ADC PARKS & GREENSPACE ARBORICULTURE

PLANNING APPLICATION: BN/26/15/RES

ADDRESS: Land North of Yapton Road Barnham PO22 0AR

BRIEF DESCRIPTION: Approval of reserved matters following outline consent BN/7/12/ for 44 No. dwellings including 30% affordable, comprising of a mix of 2 & 4 bed houses with associated landscaping & works.

**Soft Landscape Layout
Residential Planting Proposals**

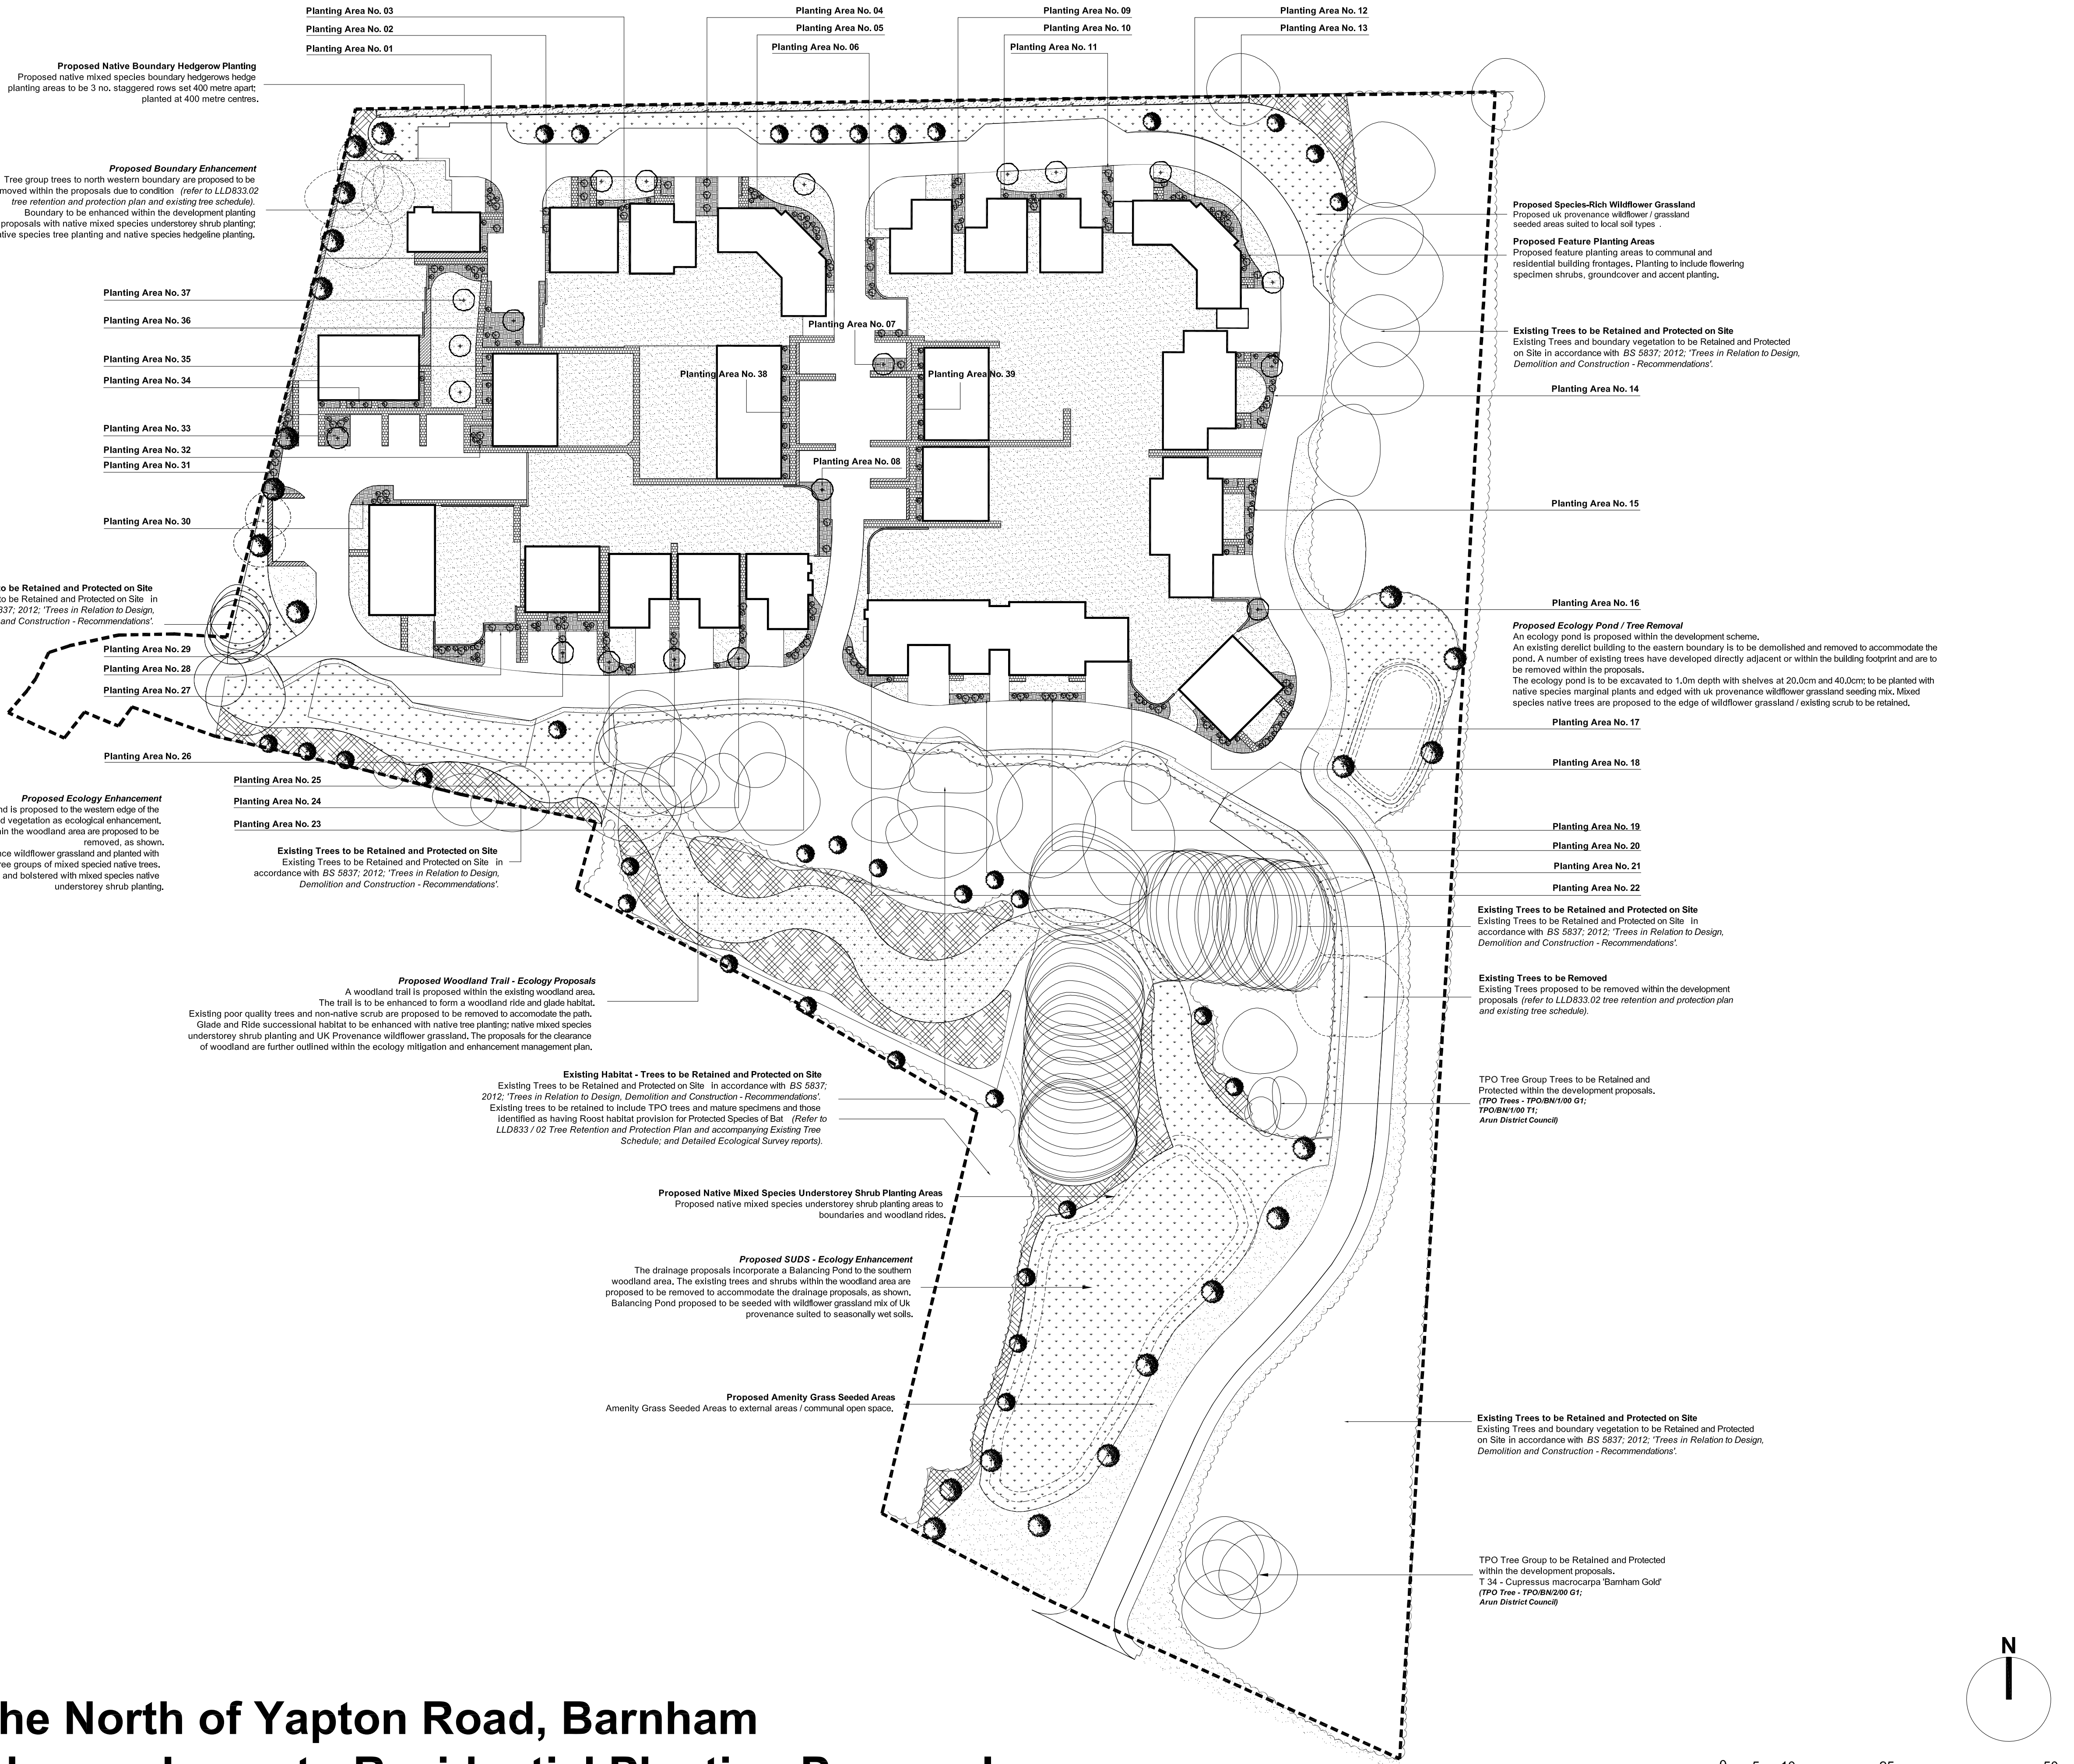
- I would have no objection to the categorisation the applicant has used for the existing tree stock. I would also have no objection to the removal of the 11 individuals (and partial removal of **TG45**). The loss of these trees however does require mitigation planting and restocking. The applicant has outlined a proposed planting scheme which would see the site populated with at least 68 newly planted trees. This repopulation should outweigh the proposed loss of 11 individuals.

- The proposed planting plan of the planting of at least 68 standard/ heavy standards must be adhered to, as to mitigate the loss of the outlined 11 standards and partial removal of **TG45**.

Tree Constraints Drawing

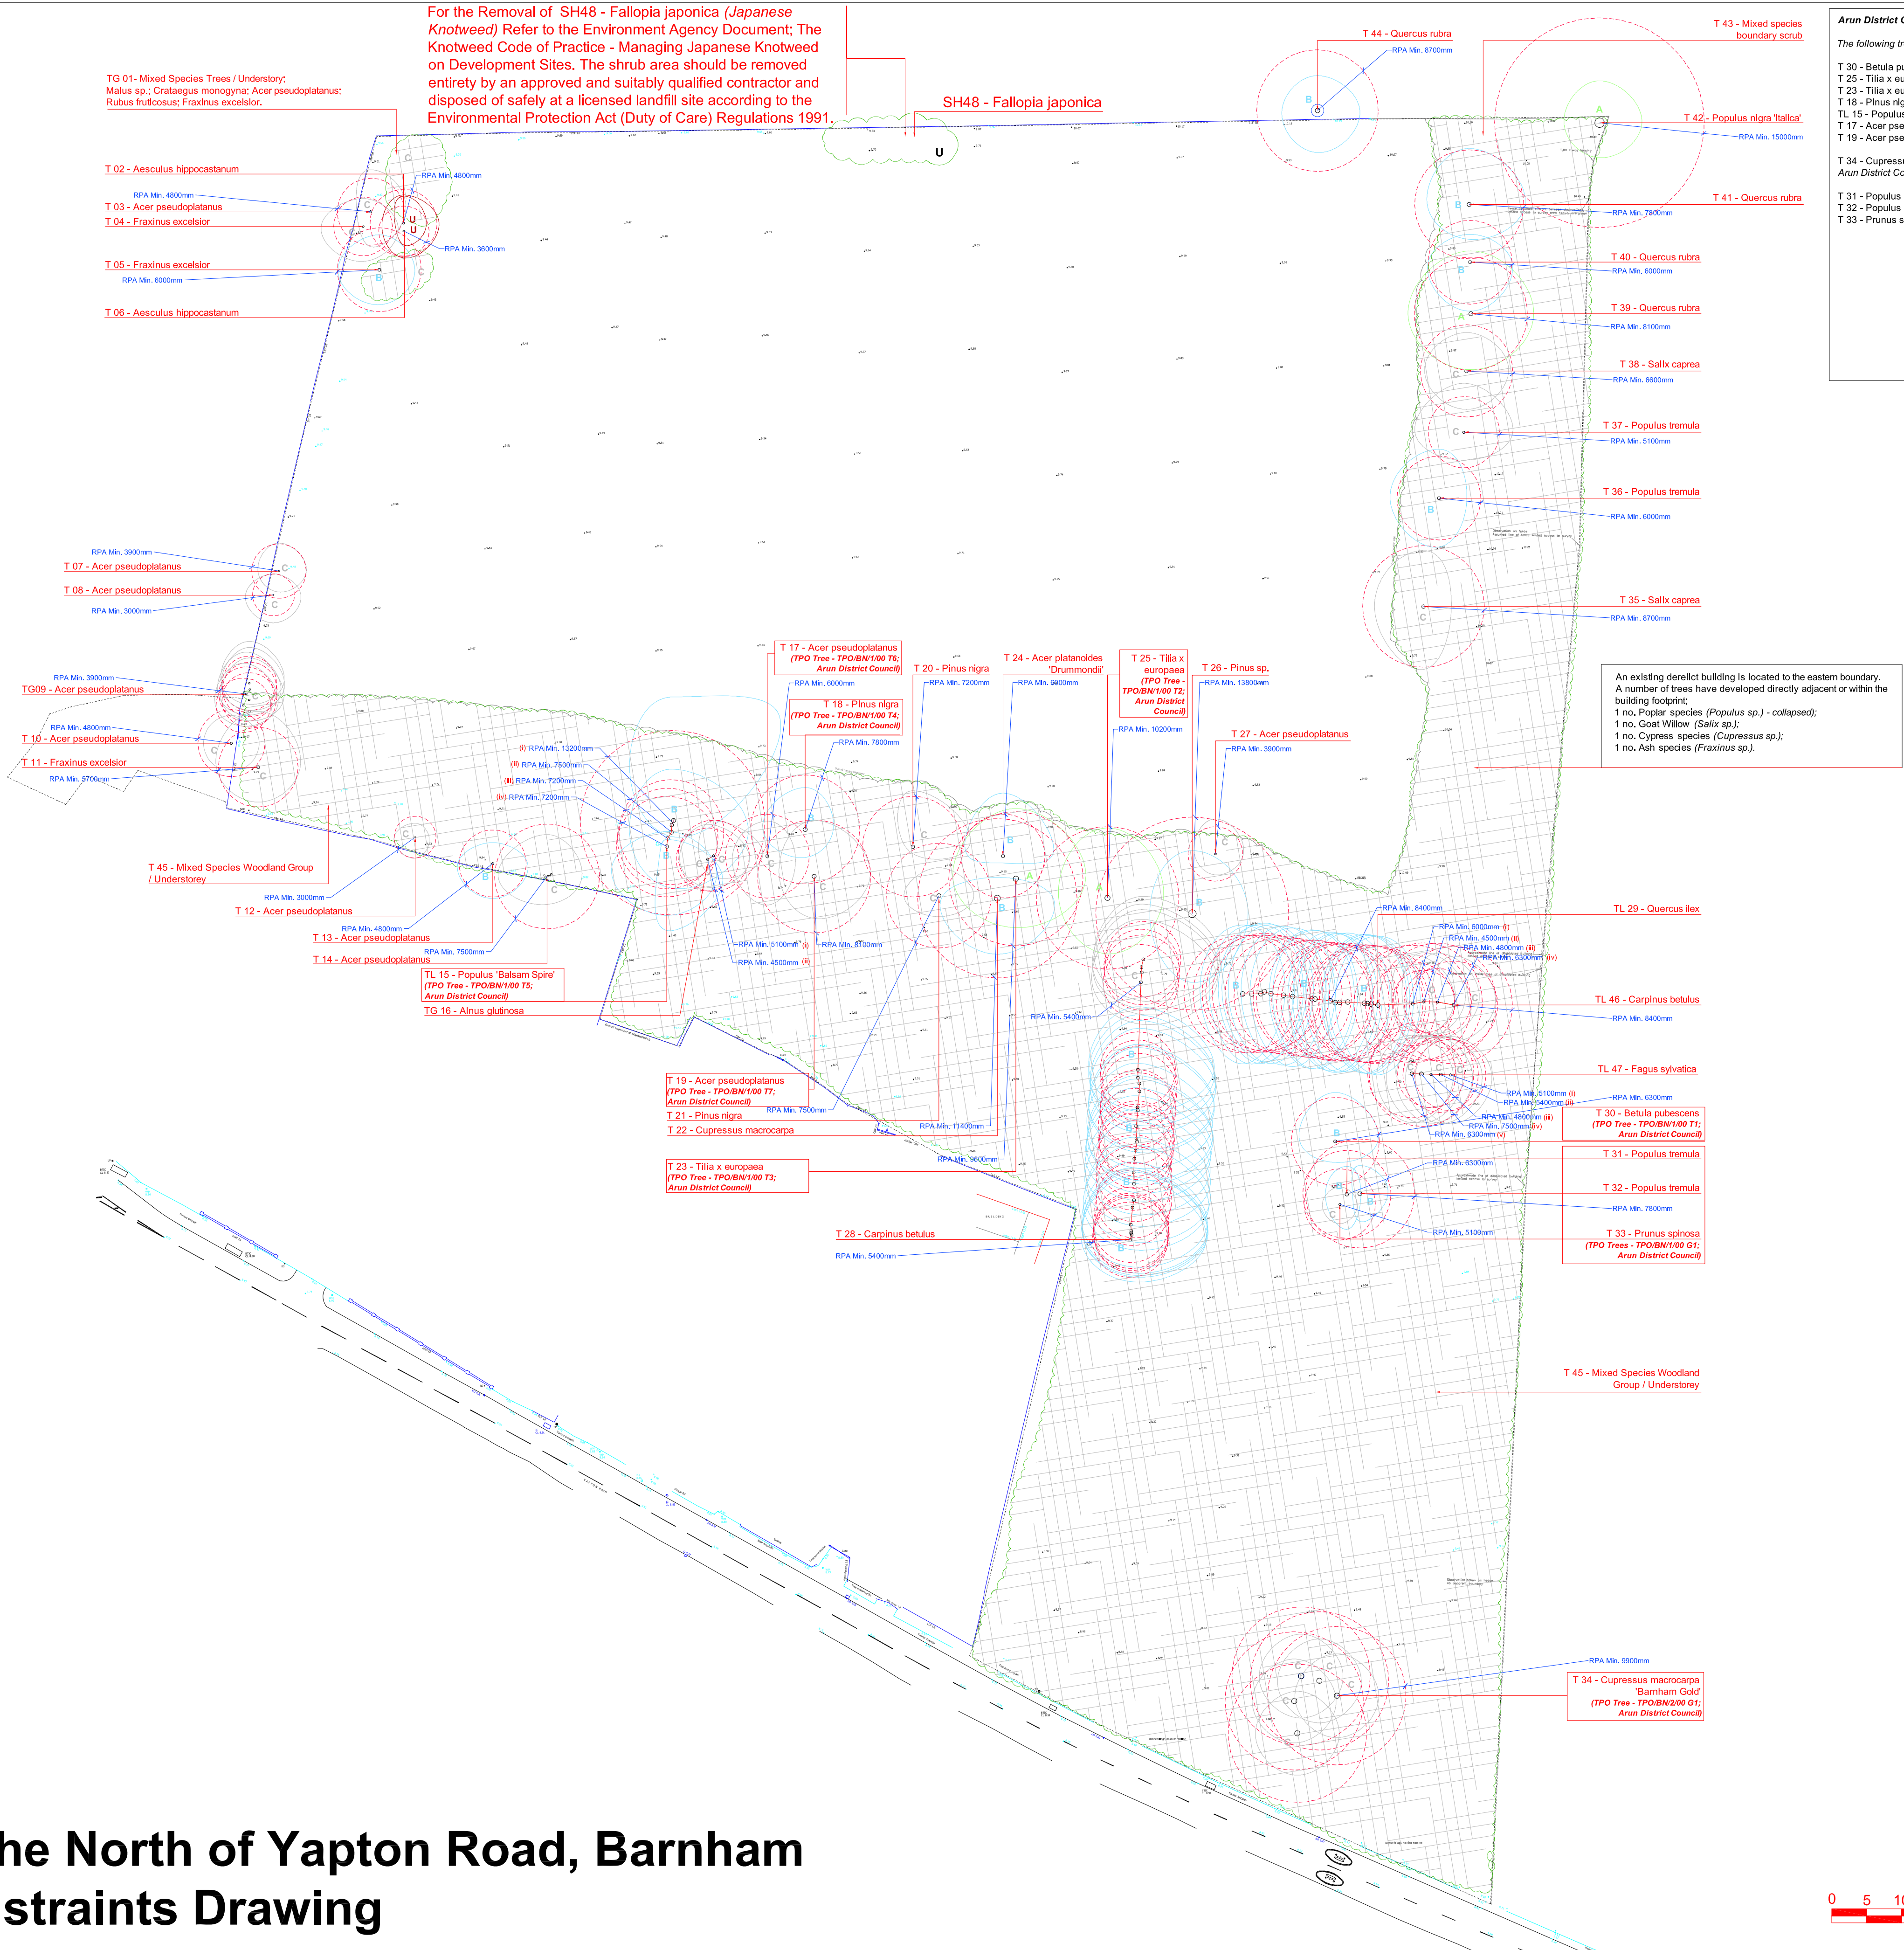
- From the site inspection it is apparent that the northern most aspect **TL15** is in a poor overall condition, and does require a remedial pruning to increase the expected retention span (due to clear evidence of systemic failures occurring to the lateral spread). The applicants stated desire to re-pollard **TL15** is likely to reduce the chance of further failures occurring.
